**KIRKLEES METROPOLITAN COUNCIL
INVESTMENT & REGENERATION SERVICE**

**DELEGATED DECISION TO DETERMINE APPLICATIONS FOR
NON-MATERIAL AMENDMENTS**

Reference No: **2025/NM/91393/E**

Description: Non material amendment to previous permission
2022/92308 for temporary siting of Dewsbury Market

Drawn	Feb 2025	Checked	
Project Number	<b>GR730141</b>	Issue Status	<b>PLANNING</b>
Drawing Number	<b>P4</b>	Revision	<b>F</b>
		Scale	<b>on dwg. A2</b>

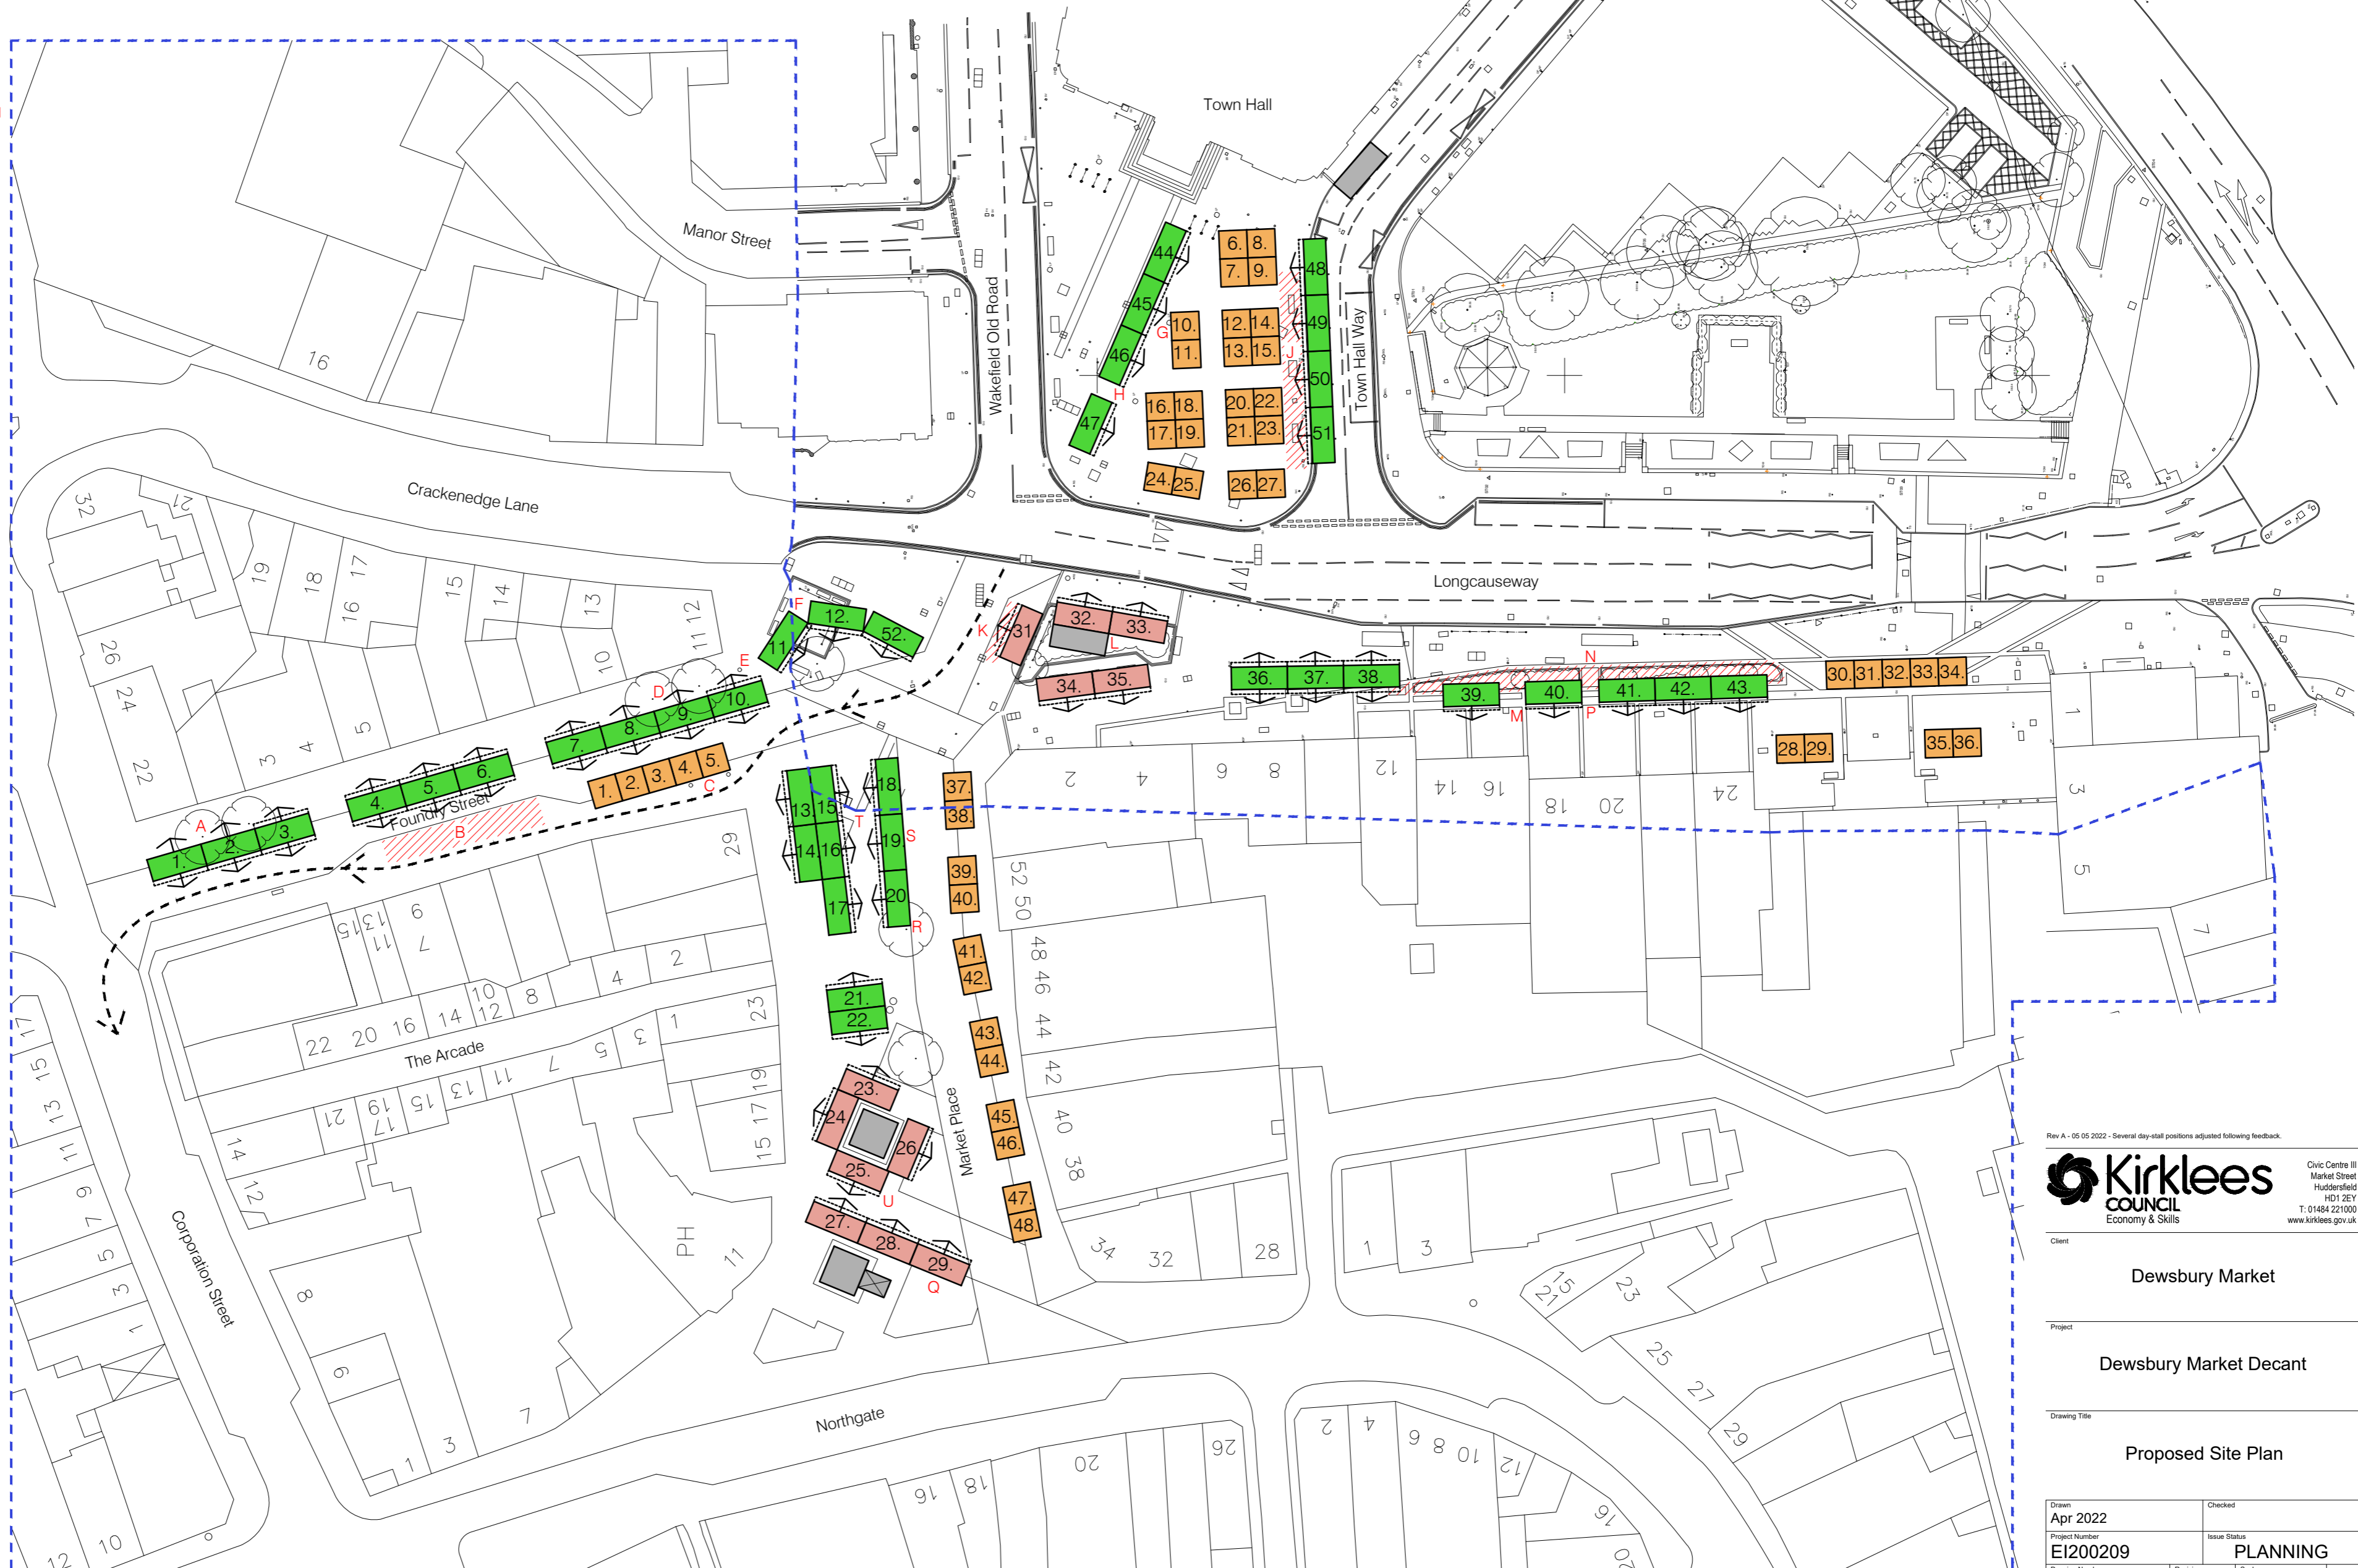
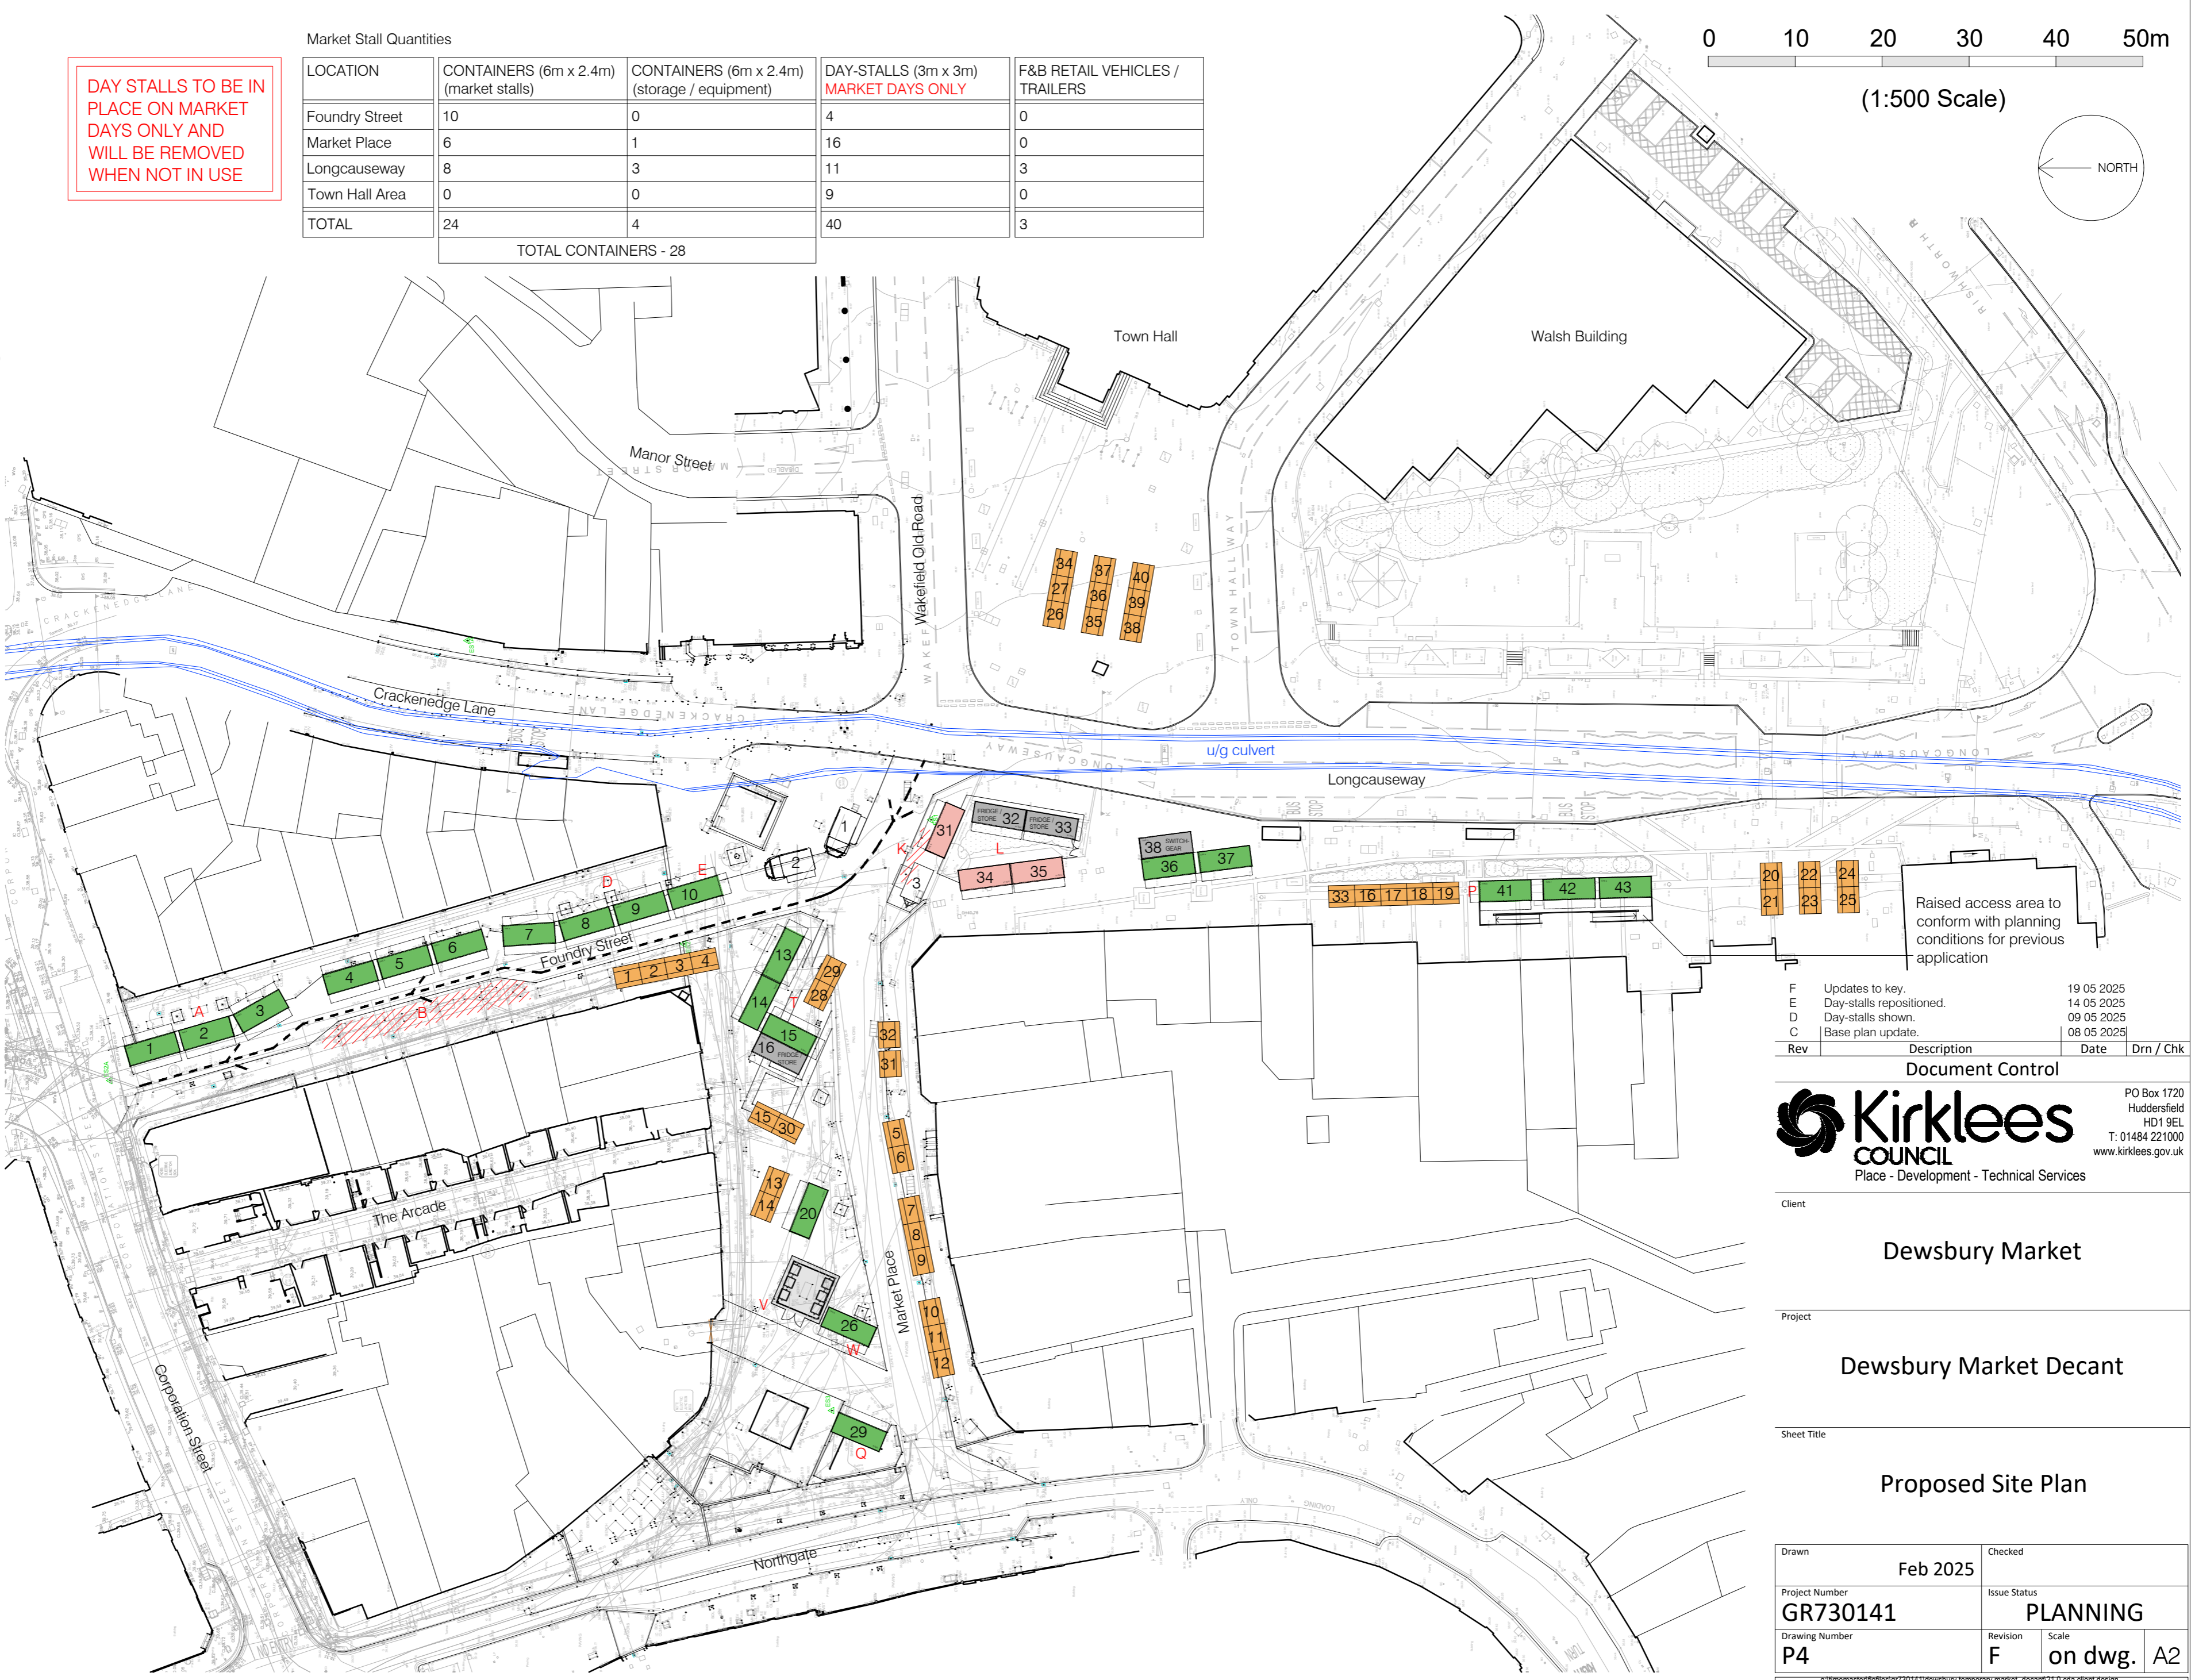
The applicant's covering letter states that the previously approved drawing illustrated 51 container stalls and 2 storage containers (53 in total), and that the revised proposal seeks to reduce those numbers to 24 container stalls and 4 storage containers (28 in total). The locations of the proposed containers approximately align with those of the approved – there would simply be fewer of them.

The applicant has explained that the proposed reduction in the number of containers is due to a change in demand and how the market is currently trading. The proposed layout is based on the discussions with traders and their preferences – of the containers which were approved in clusters (31 to 35, for example), their arrangement has been slightly amended based on traders' requests.

The applicant has also stated that containers have also been (re)positioned to avoid unnecessary clashes with street furniture and to ensure minimal disruption to the highway. Less street furniture removal would be required

The proposal seeks to reduce the numbers of containers within the temporarily relocated market to 24 container stalls and 4 storage containers (28 in total). The locations of the proposed containers would approximately align with those that were previously approved – there would simply be fewer of them.

I confirm that the changes may be considered as non-material amendments to the approved drawings. They are considered acceptable and are hereby approved.
